**Re: Woodford St Storm Drain and Baxter Boulevard Discharge**

I am not sure what action may be required on the Historic Preservation side with just crossing Baxter Boulevard with a pipe so I put a quick memo together for your review.

PLAN VIEW - 36" OUTFALL PIPE OF WOODFORD STREET CSO SEPARATION

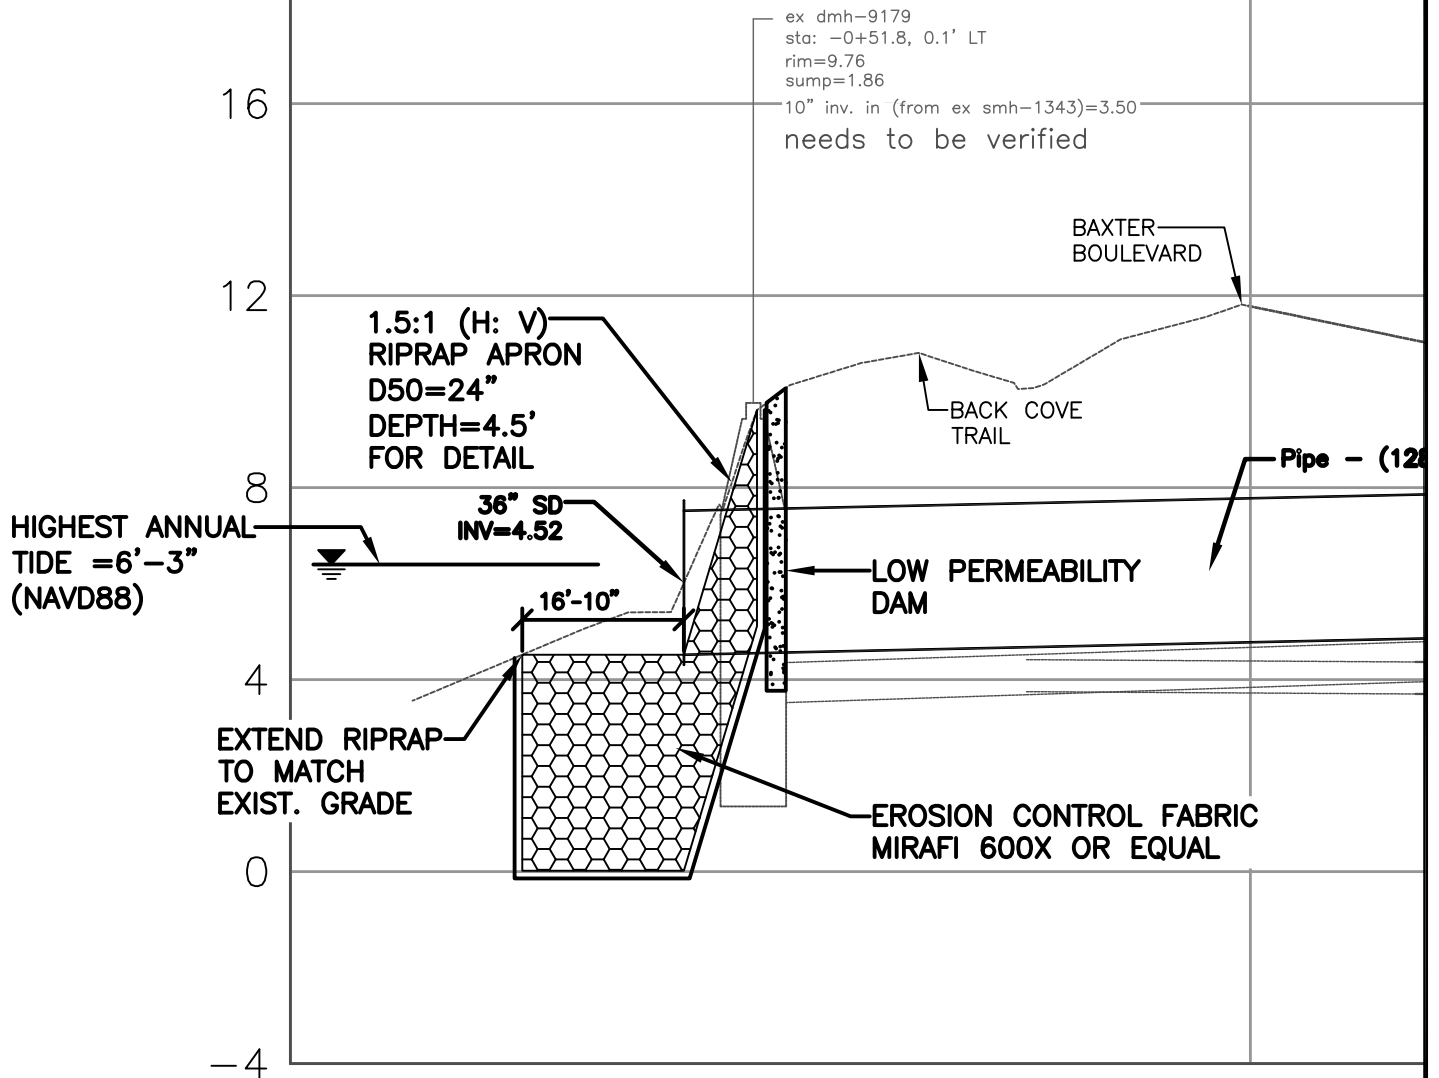
- the excavation is completely restored in-kind
- the outfall is at about the same height as, with a similar appearance to, the existing outfall nearby
